Re: Dodd Conditional Use Permit (CU-10-00003)

Upon review of the above named land use action, I have the following comments/requirements;

RE: Dodd Conditional Use Permit, (CU-10-00003)

Thank you for the opportunity to comment during the optional determination of nonsignificance process for the Whiskey Dick Ranch Bird Sporting Preserve, proposed by Darin E. Dodd. We have reviewed the documents and have the following comments.

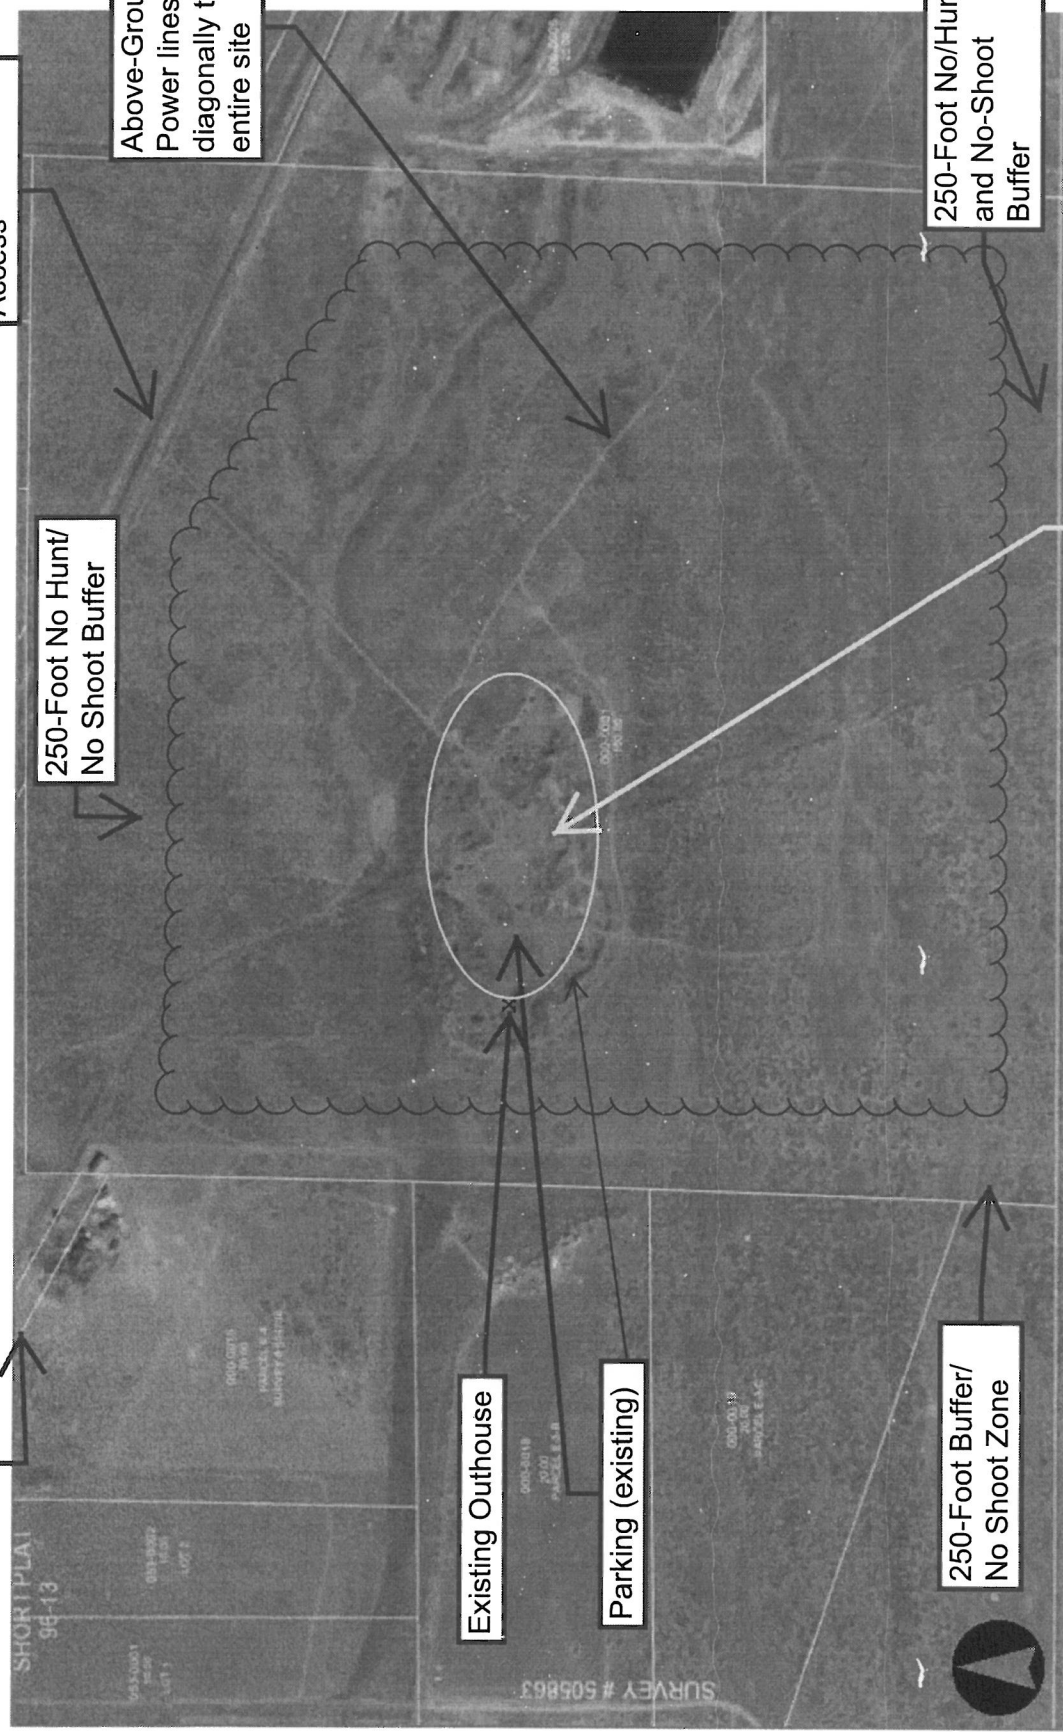
BPA does not have any objection to this conditional use permit. However, portions of BPA's easement boundary are as close as 450' from the applicant's property boundary and BPA has concerns that our maintenance crews might be working in the easement at the same time that shooting may occur. BPA requests that the landowner provide contact information so that we may notify them, to the best of our ability to do so, when work might occur in the easement area, and that their guests be notified of BPA's safety concerns. The contact information should be sent to BPA at the address at the top of this page.

Target Practice/Site of Former Shale Pit (approx. 10+ foot depression/hole with 15-30 foot berms)

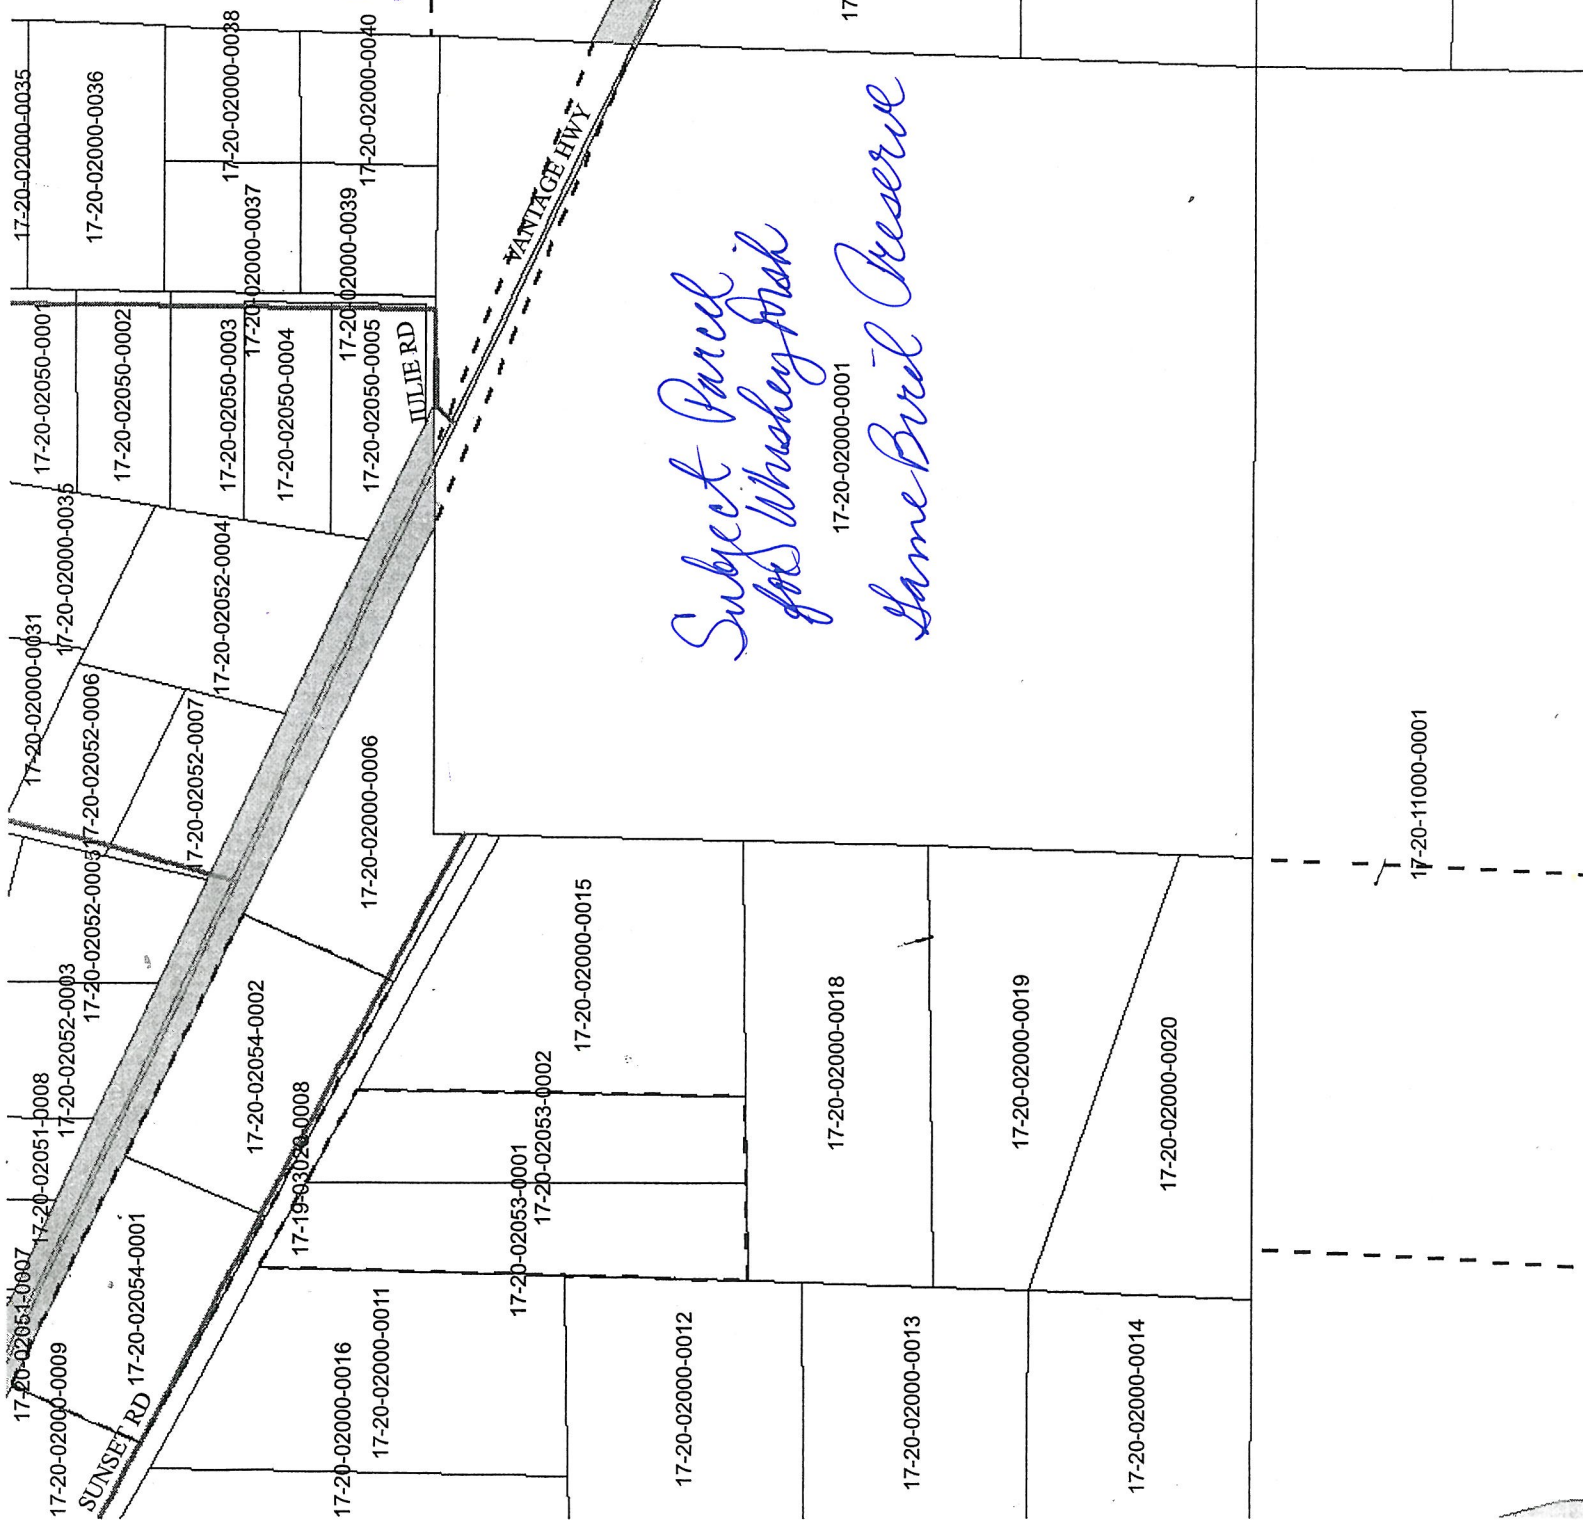
A review of aerial photos show a natural (probably ephemeral) stream corridor that splits and reunites near the depression in which target shooting will take place. The applicant states that no fill or excavation will be required at this time to use the site as a hunting reserve. Any future proposed development on this site should require further information about the natural waterway: flow amounts, duration of flow, etc. and should require appropriate setbacks to protect the stream function.
